KITTITAS COUNTY DEPARTMENT OF PUBLIC WORKS

TO: Community Development Services
FROM: Taylor Gustafson, Environmental/Transportation Planner
DATE: July 17, 2018
SUBJECT: County Survey Review of BLA BL-18-00008 (Clark)

CLARK PROPERTY

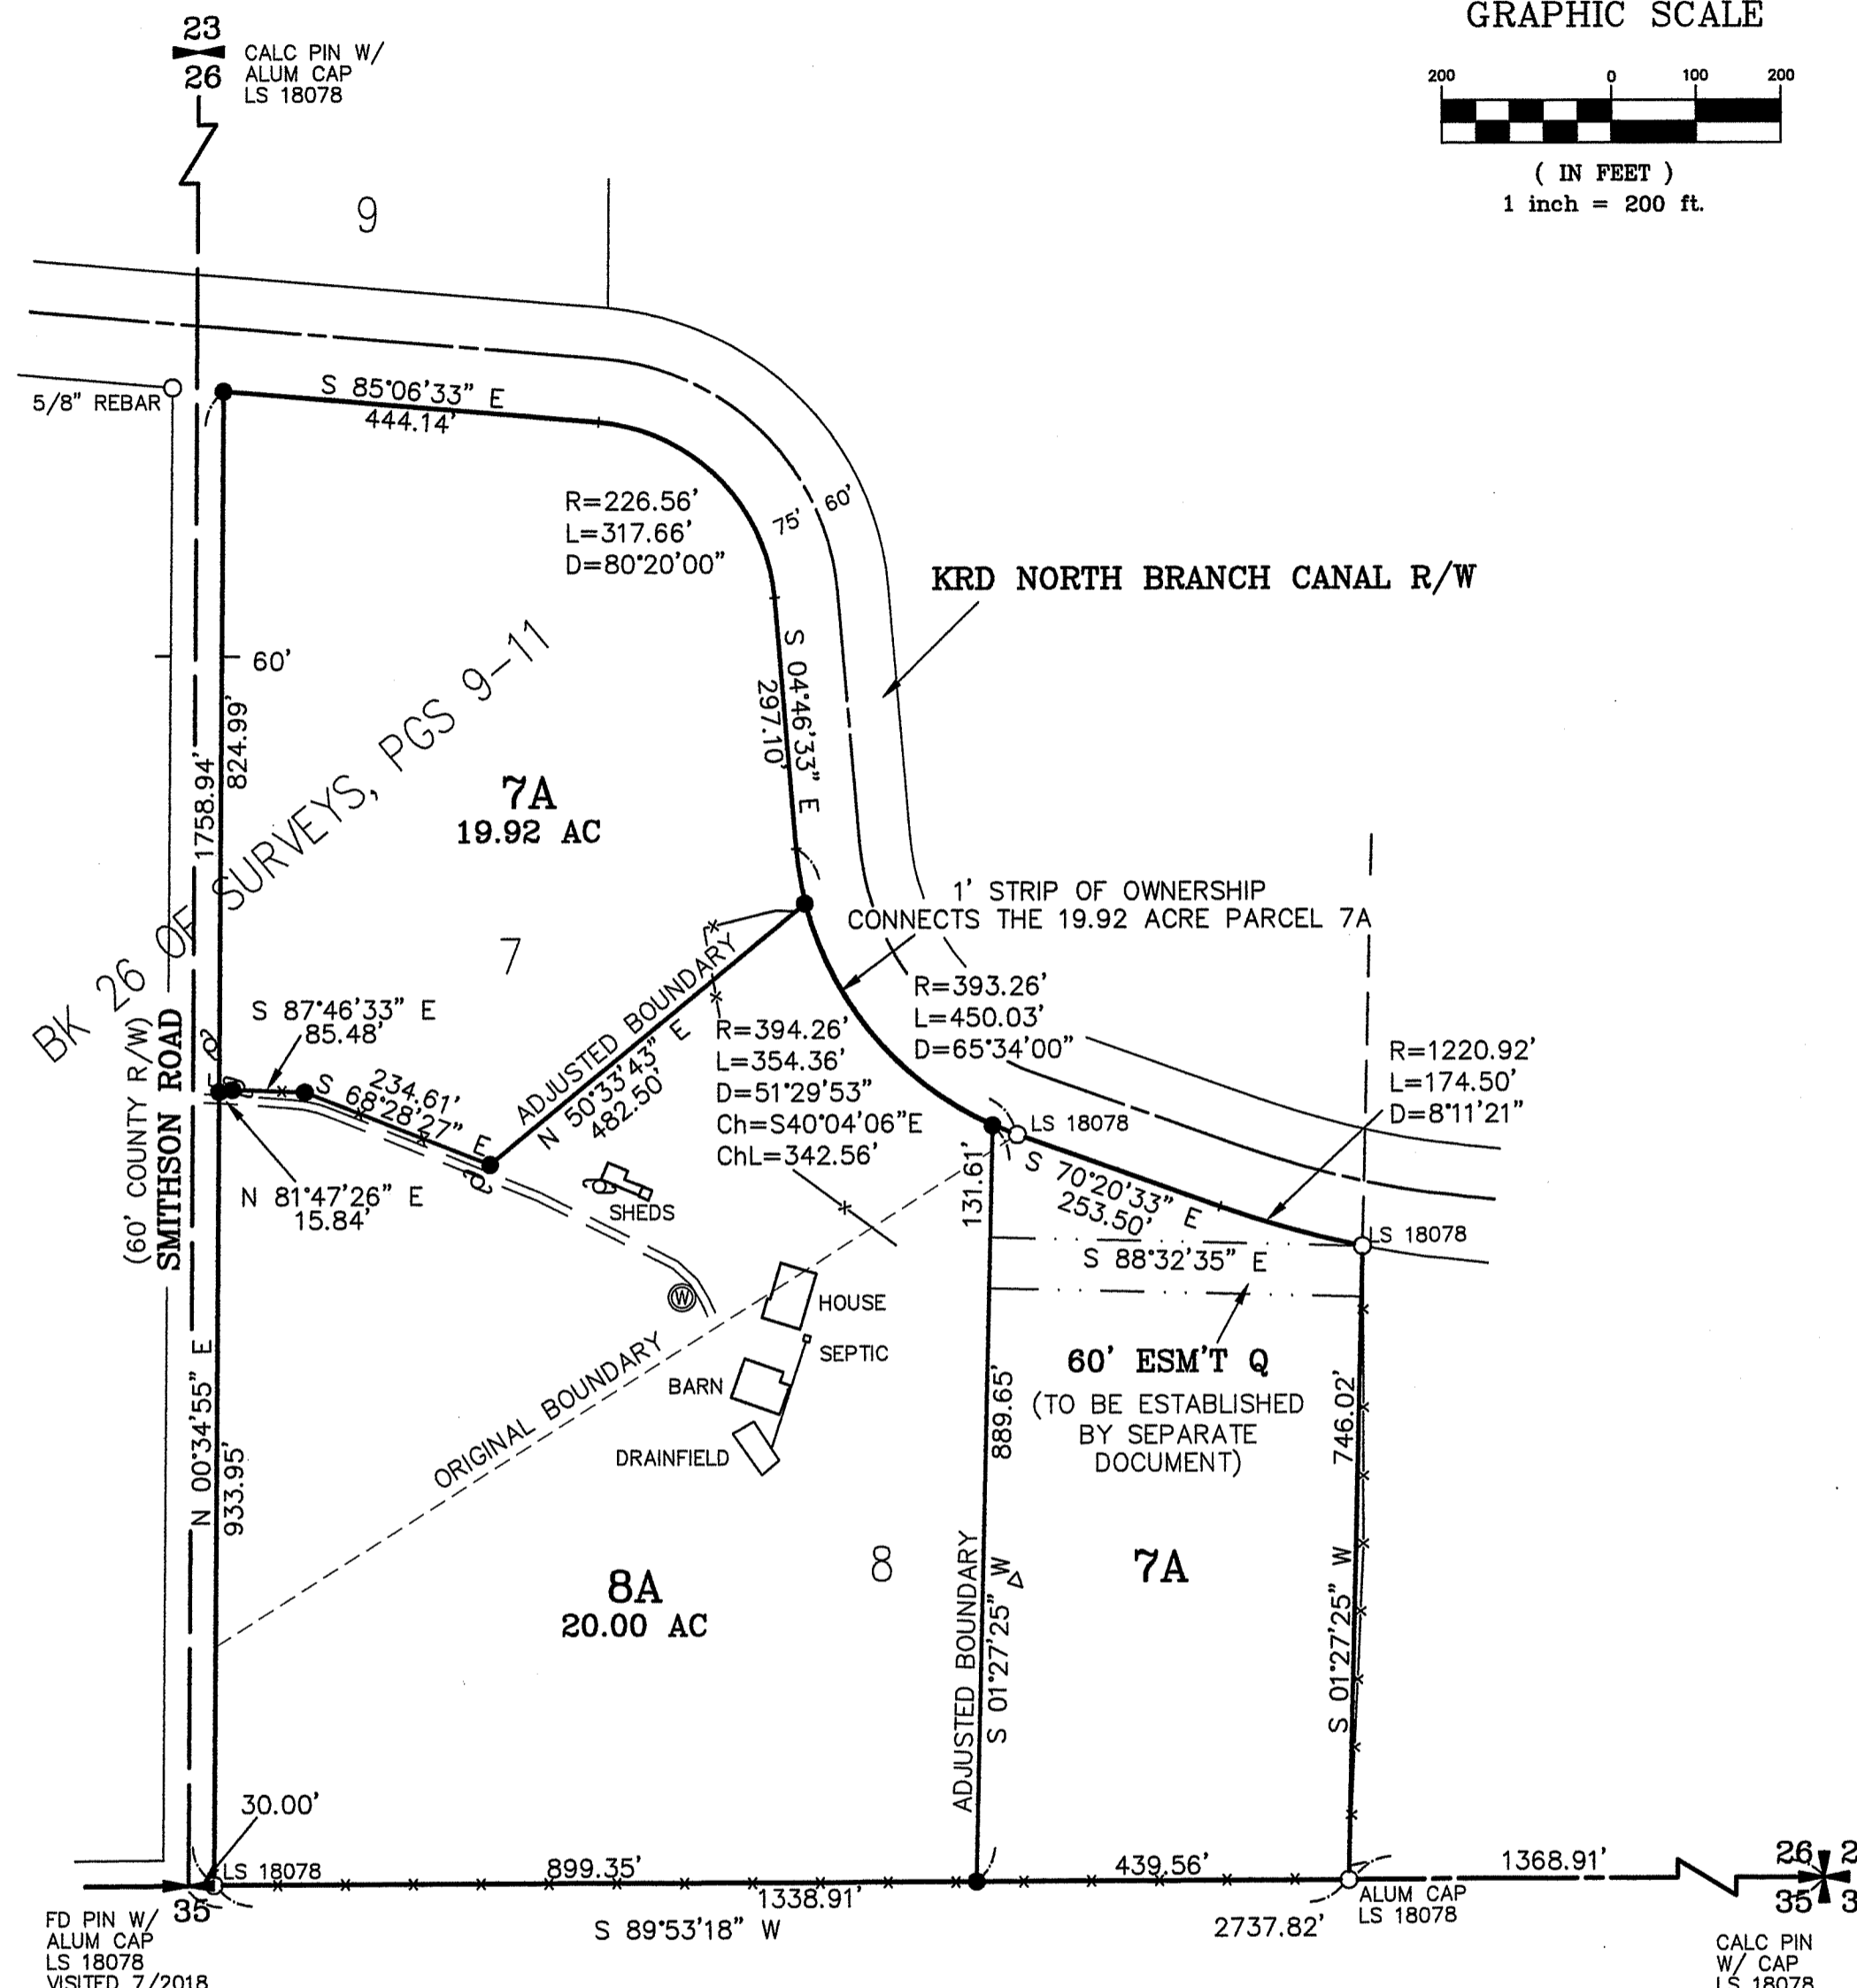
1. A note should be added stating the purpose of the survey together with the application number (KCC 16.10.020(1)).
2. Surfacing type of Smithson road should be included (60' County R/W - Gravel).
